**Havering**  
LONDON BOROUGH

**London Borough of Havering (20025659) – Response concerning TR010029 9.5  
Transport Assessment Supplementary Information Report**

This letter sets out London Borough of Havering's (Havering) response to TRO10029 9.5 Transport Assessment Supplementary Information Report submitted by Highways England (HE) as part of Procedure Deadline 1.

Figure 6-1: AM peak changes in traffic flows due to construction

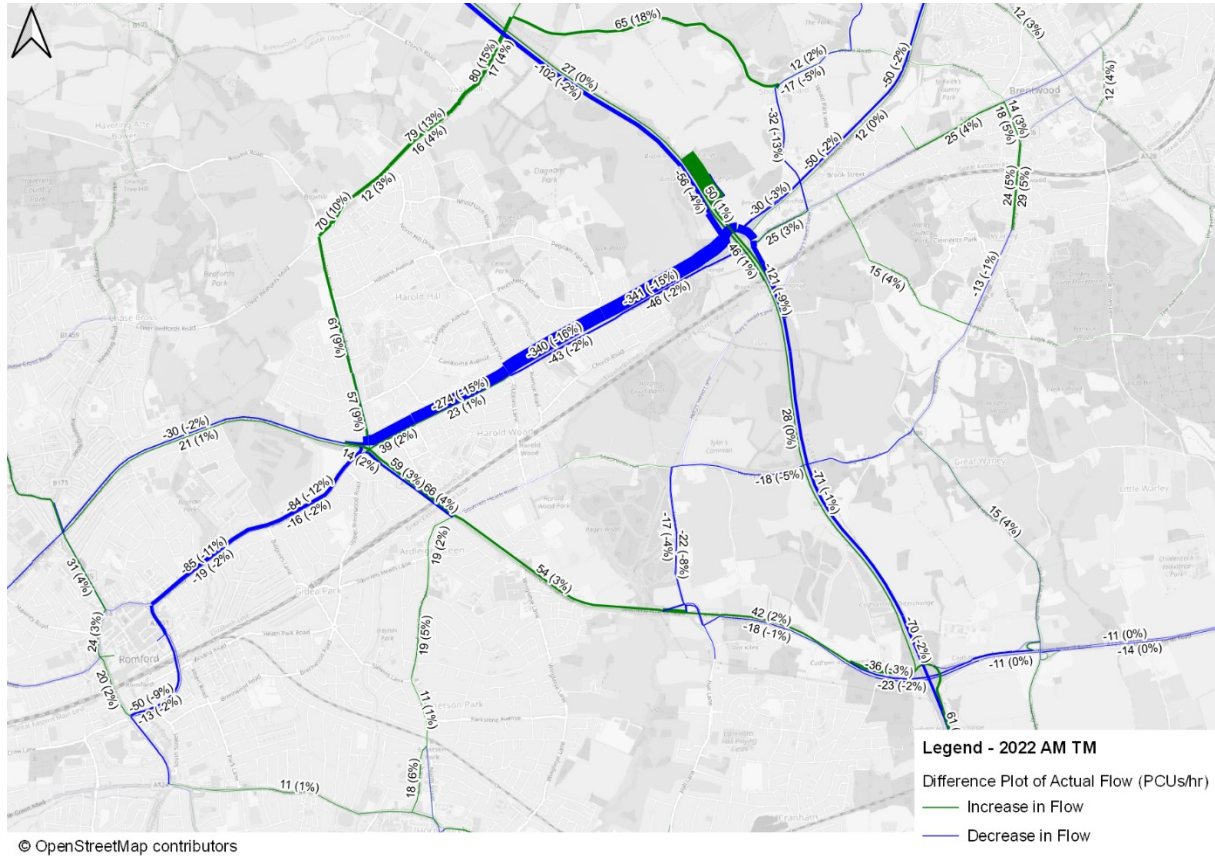
Figure 6-1 AM peak changes in traffic flows due to construction illustrates the trip redistribution with 9% additional trips in the AM peak travelling up Straight Road (57-61 additional trips) and an additional 10-15% additional trips travelling up Noak Hill Road to the north of the A12 Road (70-80) trips. These routes are also subject to additional trips in the inter peak and the PM peak but to lesser extent than the AM peak.

Drawing Title: **PETERSFIELD AVENUE
CONSTRUCTION TRAFFIC U-TURN
SWEPT PATH ANALYSIS
ARTICULATED VEHICLE**

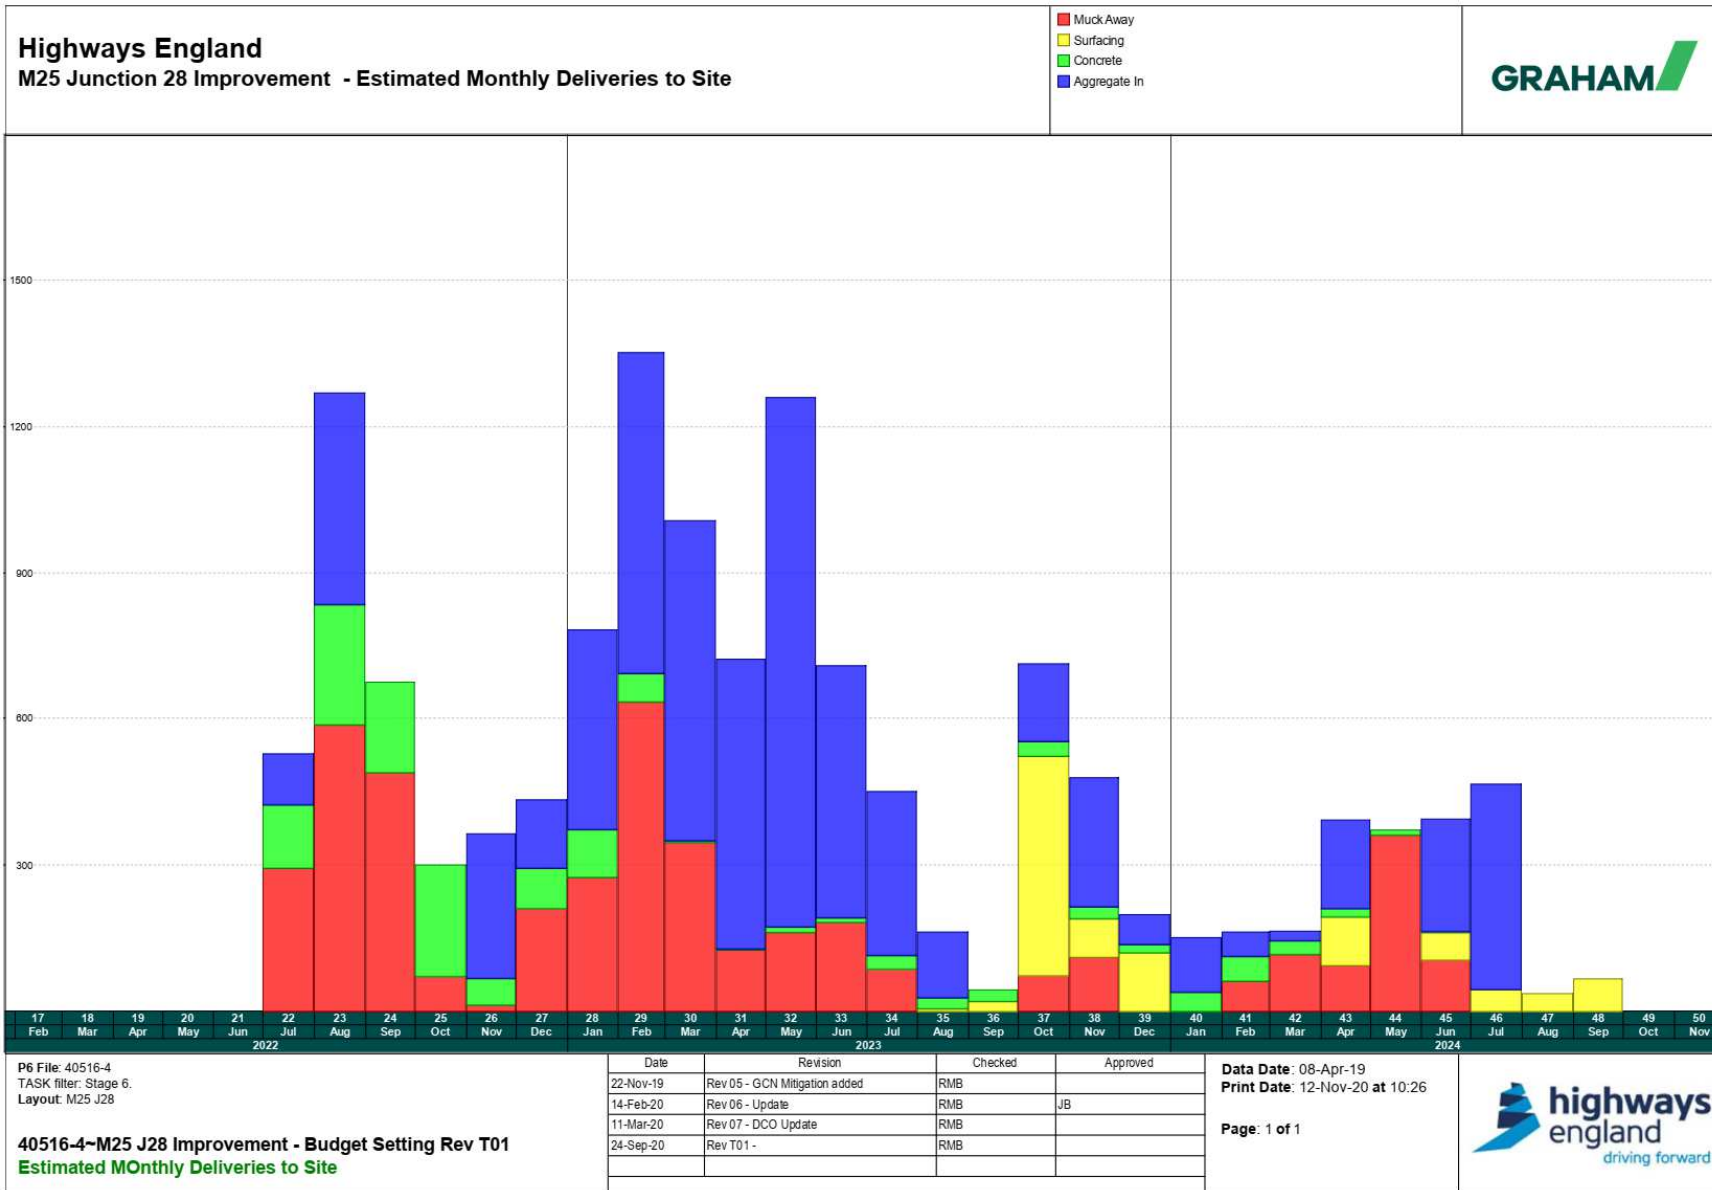
Havering notes with concern the U turn movement that is proposed at the A12 junction with Petersfield Avenue. This movement will be a difficult movement for HGV’s to make due to the narrowness of the lanes and the tight turning circle. There is also potential for HGVs to project into the middle land of the de-restricted A12 when making this movement, i.e. queuing in the filter lane or when making the right turn movement.

Havering request that HE provide swept paths for these proposed movements to demonstrate that the proposed movement can be carried out safely.
